From: Richard Temple
Sent: 22 January 2018 16:52
To: Planning.Responses
Subject: FW: Planning Consultation Greenspace on: WA/73/17/OUT

APPLICATION NO: WA/73/17/OUT

Site Address: Land East of Wandleys Lane and West of West
Walberton Lane Fontwell

Description of Works: Outline Planning Application with some matters reserved for up to 157 No. residential dwellings including 30% affordable. This application is a Departure from the Development Plan.

Drawing title: Tree Retention Plan

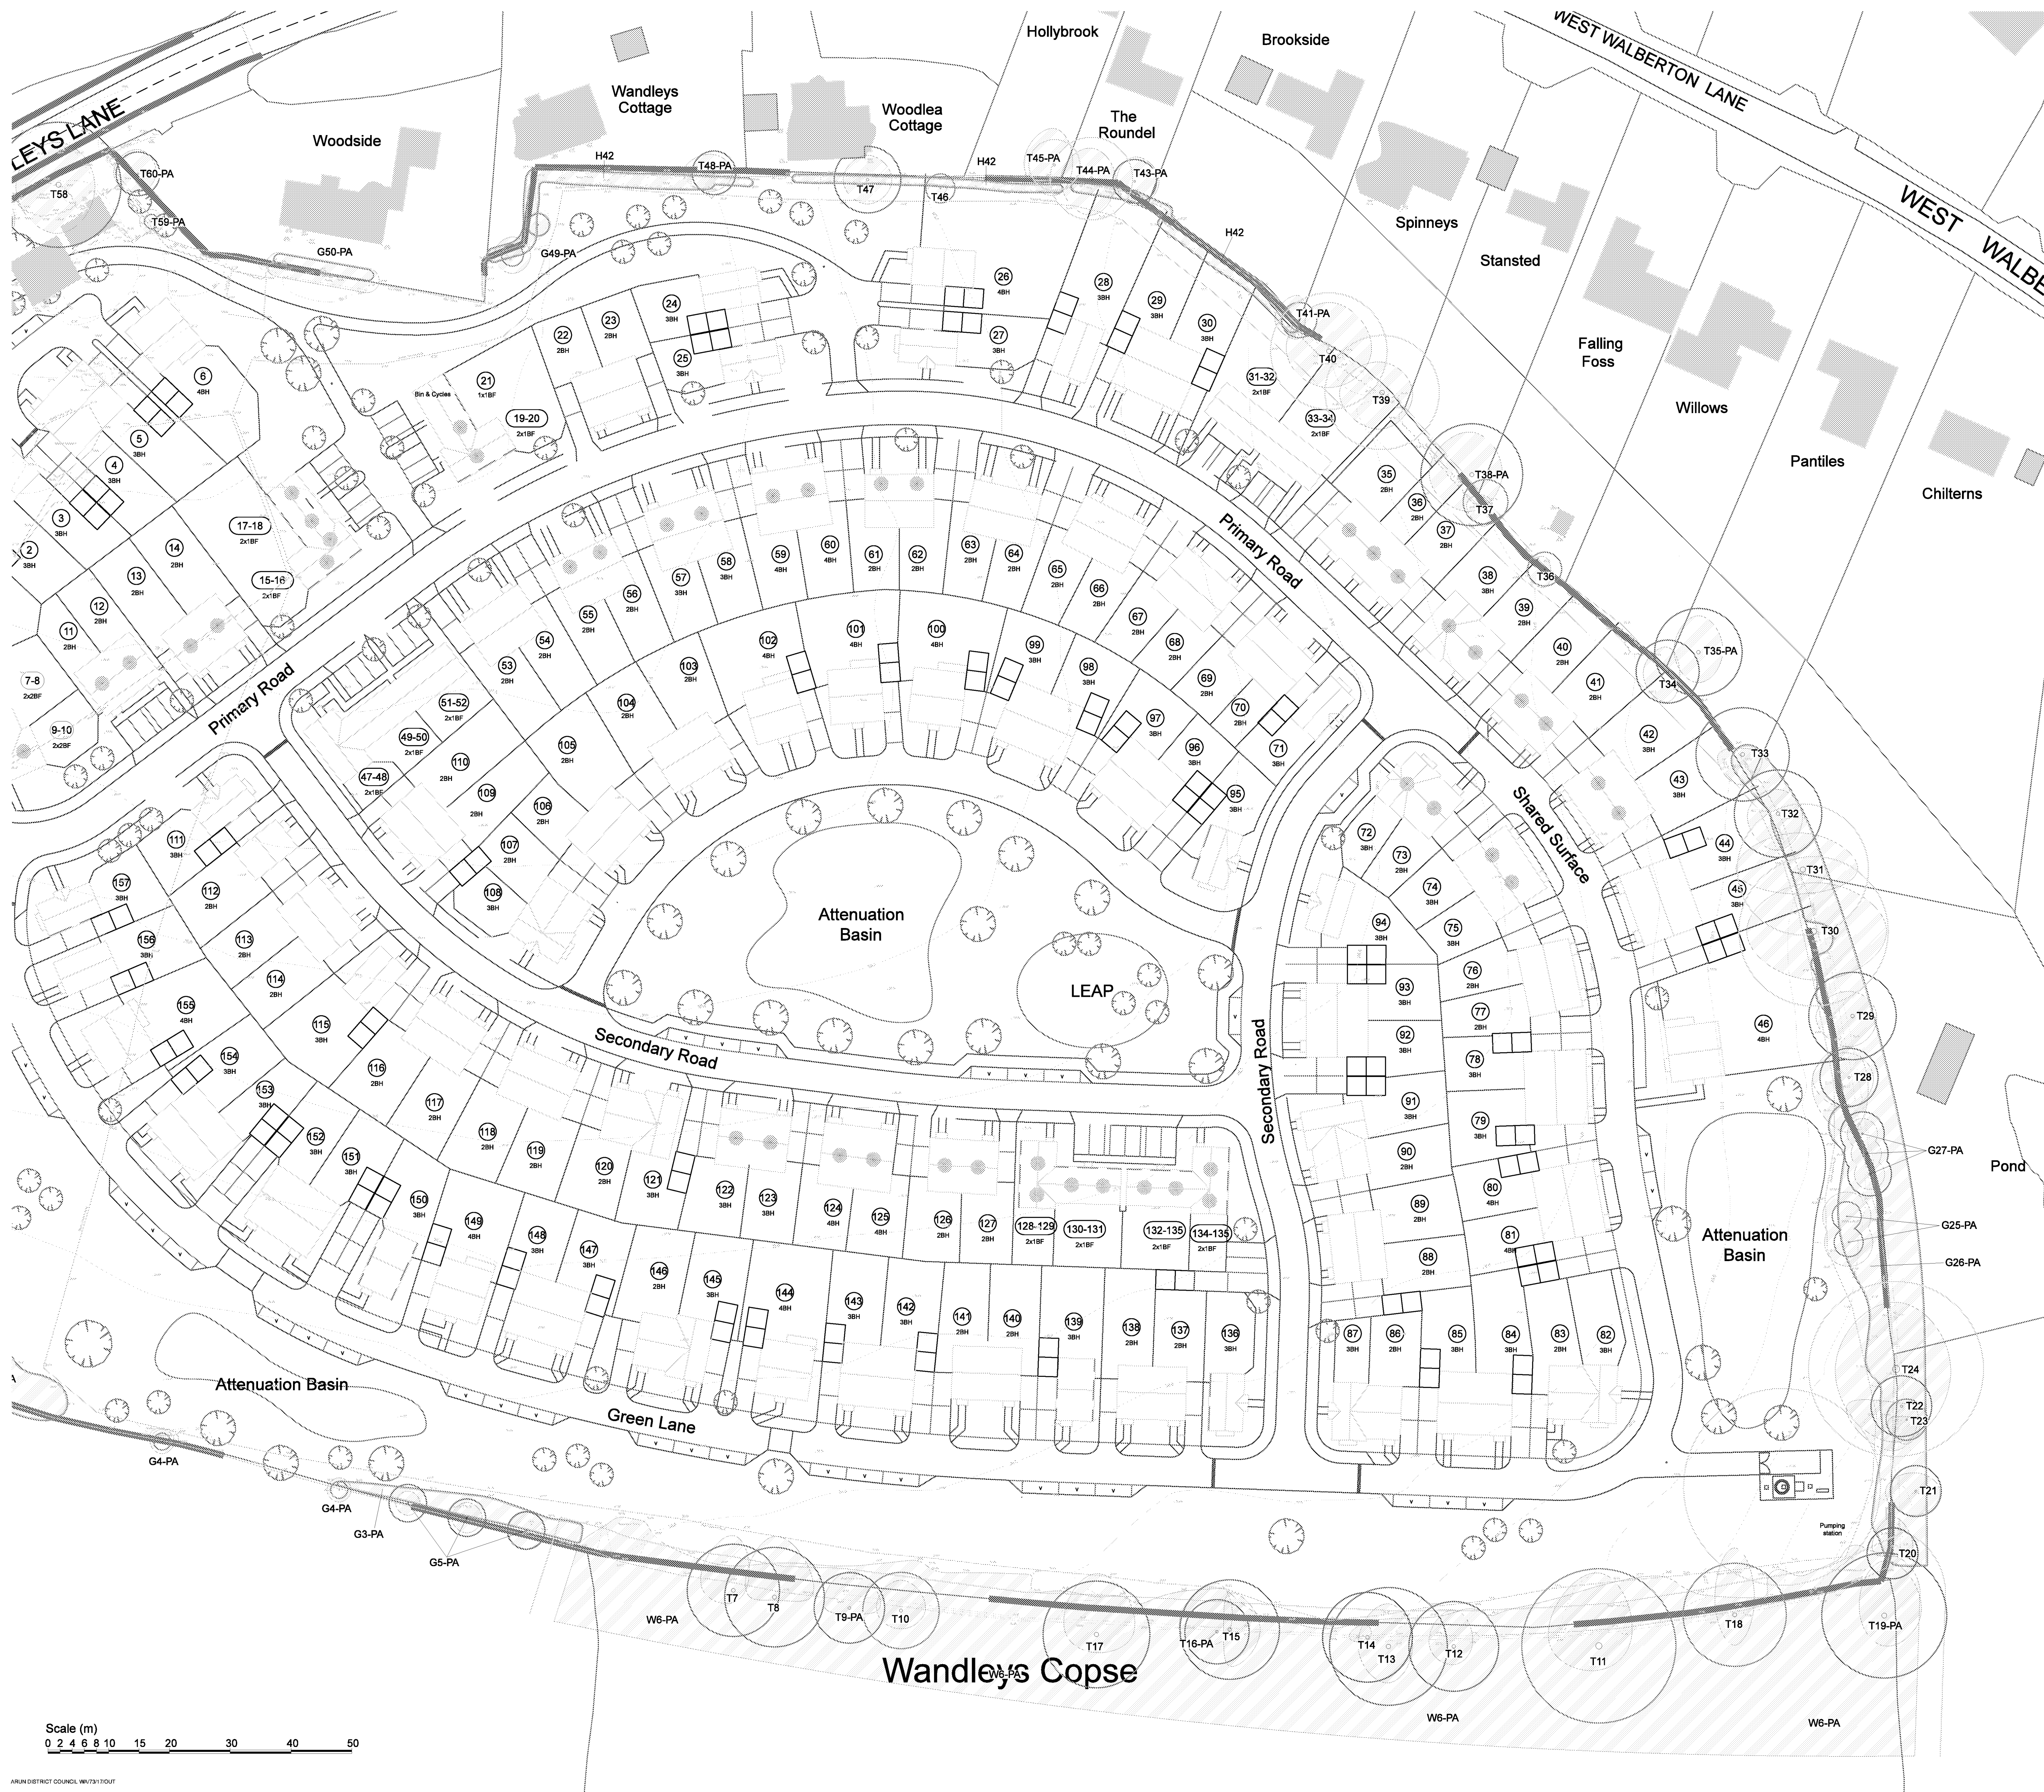
A tree survey has been submitted which takes into account proximity to the semi-ancient natural woodland at Wandleys copse. A buffer zone in the form of POS has been shown to this area where access and footway links will require further detail as the layout is confirmed.

Any significant existing trees along the boundary edge should be identified for retention and must be protected during the works if they are identified to provide good visual amenity in addition to their biodiversity importance. Any trees that have the potential for a long life expectancy, with potential to become a prominent feature within the landscape and are worthy of protection, with adequate fencing according to the BS5837 (2012) Provision for fencing according to each of the trees' correct and calculated root protection area must be erected prior to the commencement of any development activities.
